St James Senior School,  
Ashford  
Esso's Southampton to London  
Pipeline Project – Comments  
on Applicant's and School's  
alternative pipeline routes  
Prepared for St James School  
January 2020

### **Esso's Southampton to London Pipeline Project – Comments on Applicant's and School's alternative pipeline routes**

**Figure 2: Plan Showing Listed Buildings and Curtilage Listed Buildings at St James School**

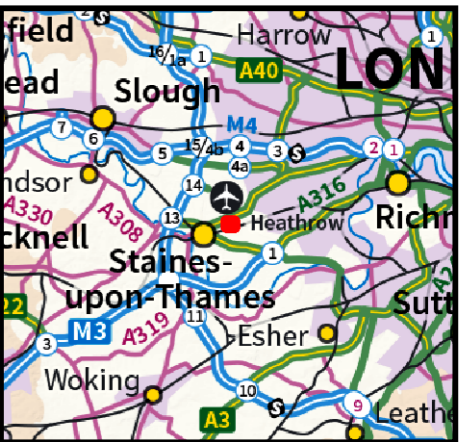
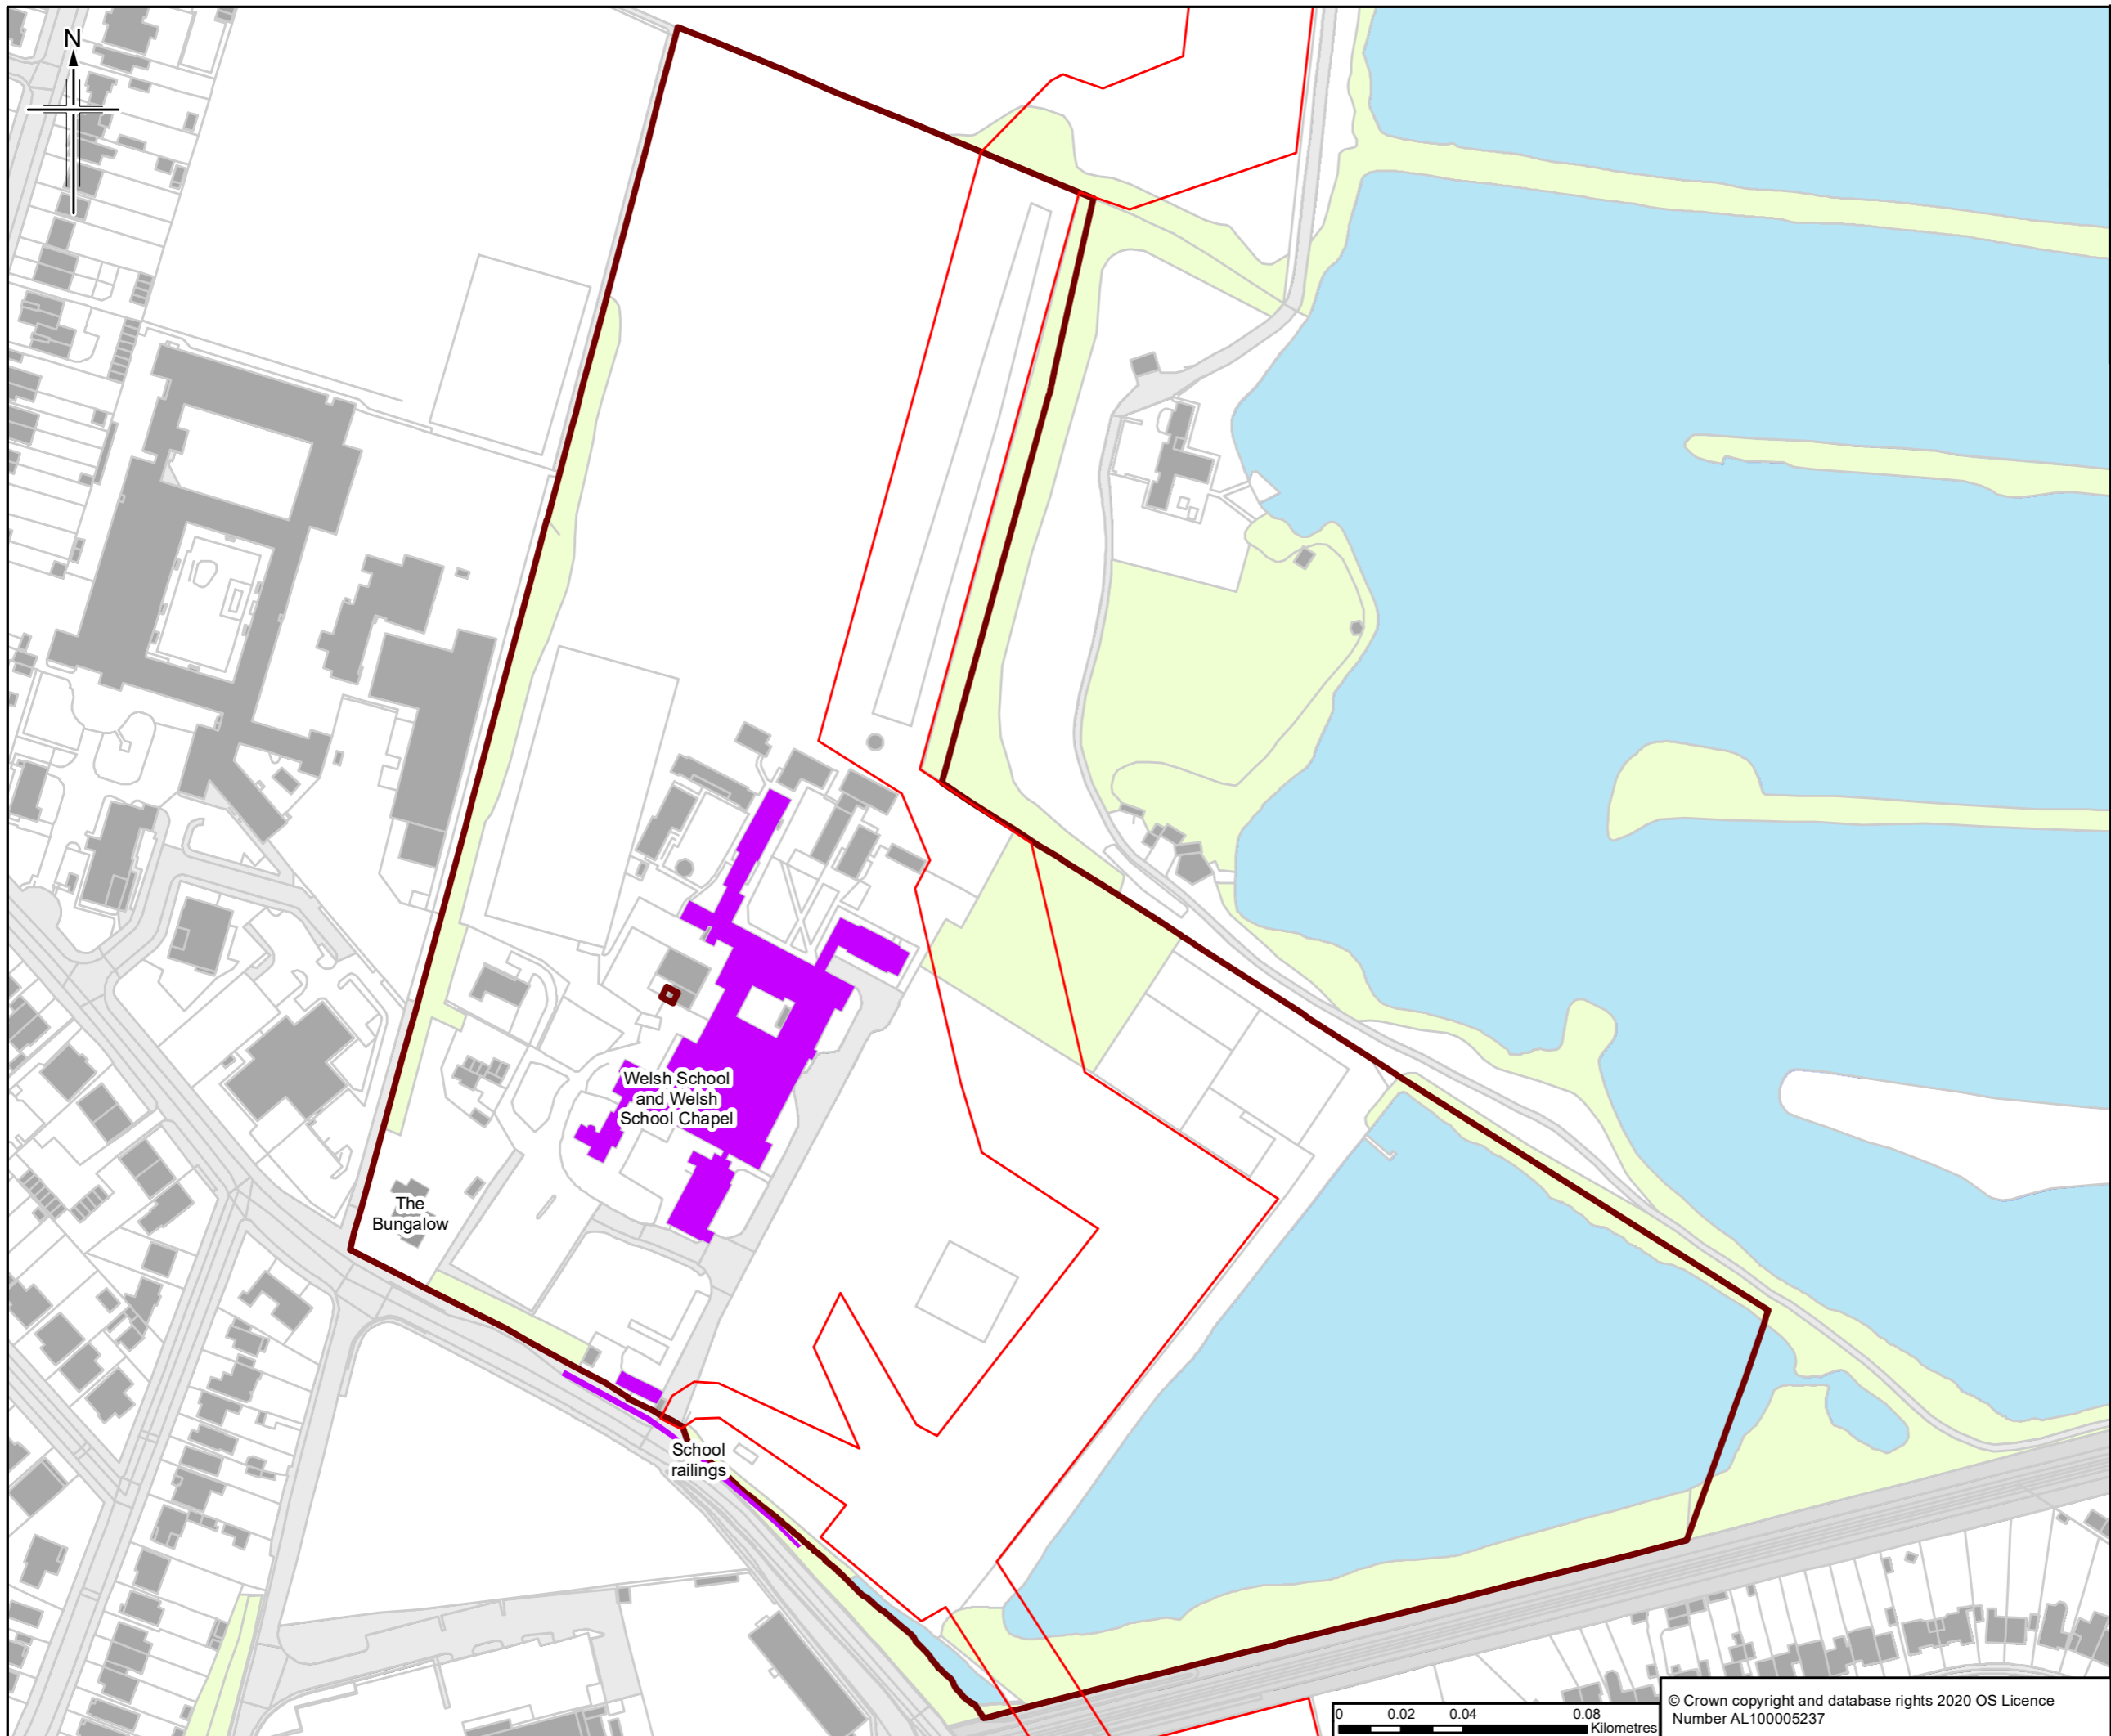
- 4.3.6 Esso have also assessed this option as having a greater impact on Cultural Heritage with construction activity and the pipeline route closer to listed buildings. However, the proposed alignment for Scenario 1b would only involve construction adjacent to the grade 2 listed gatehouse, whereas Esso's proposed option would still impact on the gatehouse as the school entrance is shown as being used as a construction access, and also require construction close to the grade 2 listed chapel as shown on SK 9 attached.

Any impacts on Cultural Heritage are only temporary impacts during the construction phase, and therefore of limited significance.

Illustration 3.1: Plan showing the Order Limits and working strip through St. James School

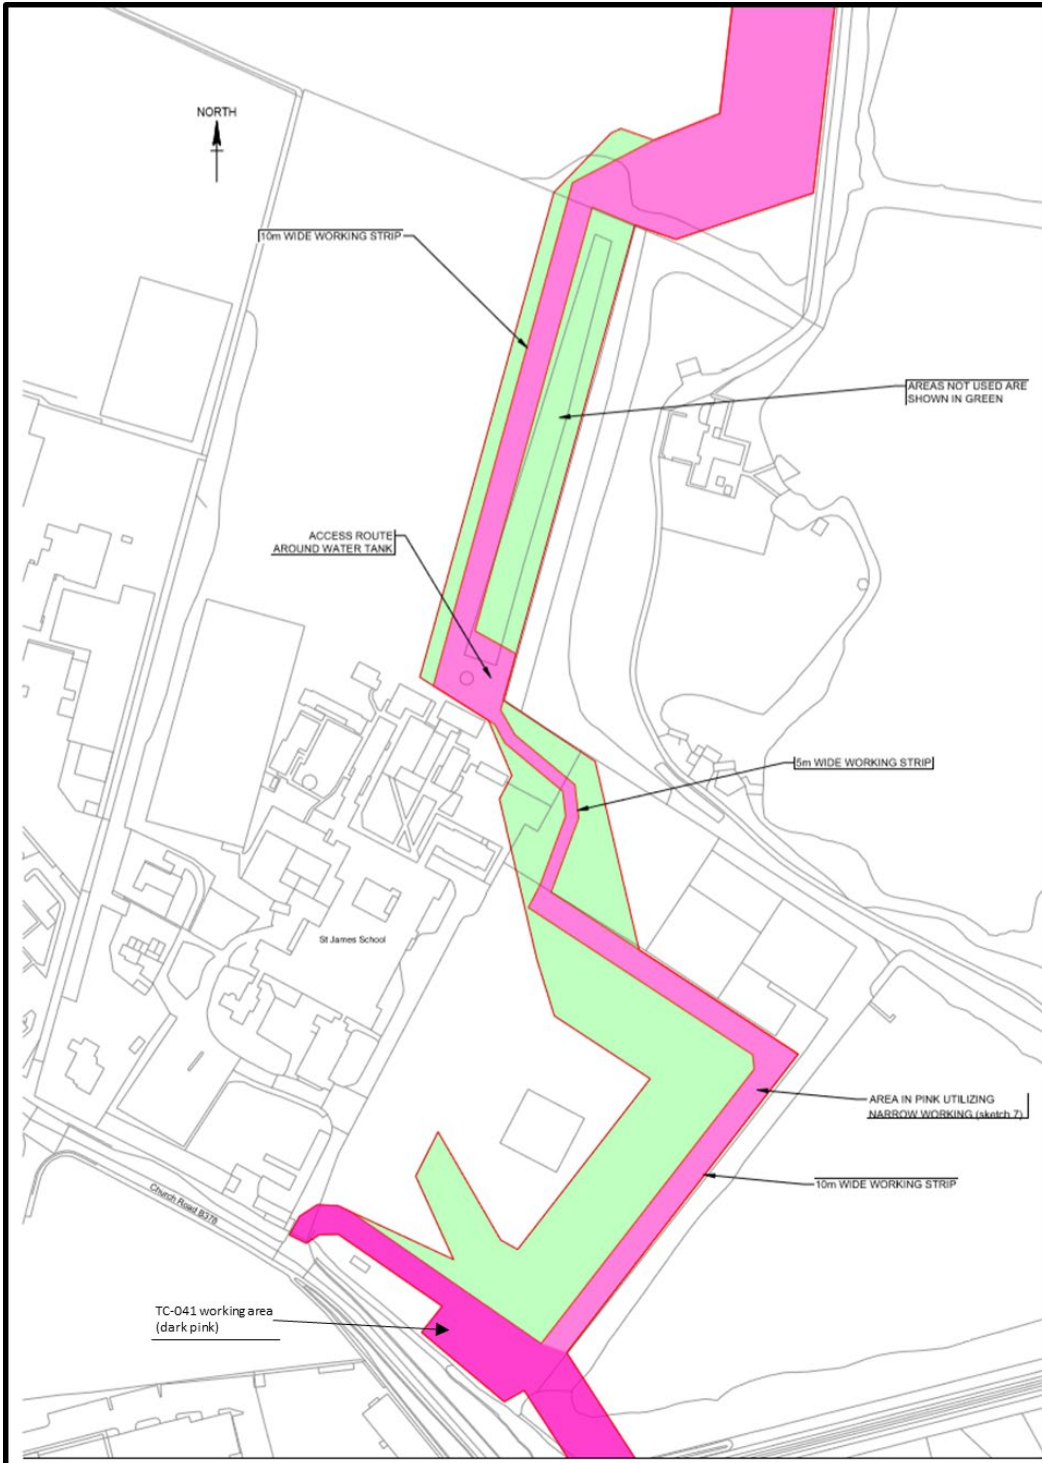
Esso's proposed route extends through the school grounds along the eastern edge of the sports pitch adjacent to the lake before passing close to the Grade II listed Chapel Tower and through a TPO area into the northern playing fields, extending along the eastern boundary until the northern exit point of the school grounds as shown in sketch 1 in SLT's Technical Note. Esso

A significant issue not considered in SLT's Technical Note is the high ground water level within the gravel adjacent to the lake. As noted in section 2.3, water levels recorded in Soils Ltd site investigation for the proposed sports hall record water levels as very similar to the water level within the lake obtained from lidar data. Consequently, the water table in the ground is likely to be hydraulically linked to the lake. Lidar data records existing ground levels along the eastern side of the east playing fields at around 14.7m AOD which is only 1.4m above the water level in the lake. An excavation depth of around 1.8m would be required to lay the 300mm diameter pipe on a suitable bedding and with the required minimum 1.2m cover over the pipe. This would require excavating below the water table adding significant cost and complexity to the installation of the pipeline. Measures would be required during construction to prevent the pipe line floating. See section A-A on SK 3 attached.

It is likely that a dewatering technique such as well point dewatering would be required to lower the water table below the underside of the trench excavation. This is a specialist technique which would require site investigations to establish the permeability of the soils and pumping trials to determine the extent of works required, particularly with the close proximity of the adjacent lake. Trench supports may also be required to maintain stability of the sides of the trench excavation. It is unlikely that Esso would be intending to undertake detailed site investigations at this stage, so this remains a significant cost and programme risk for their preferred option.

Importantly, Esso do not seem to have considered the construction impacts on their preferred option of the high water table within the gravel layer below the eastern playing field which would seem likely to add significant cost and complexity to the construction of their preferred route. The higher ground level along the western boundary of the school means this is not a consideration for the School's alternative scenario 1b.
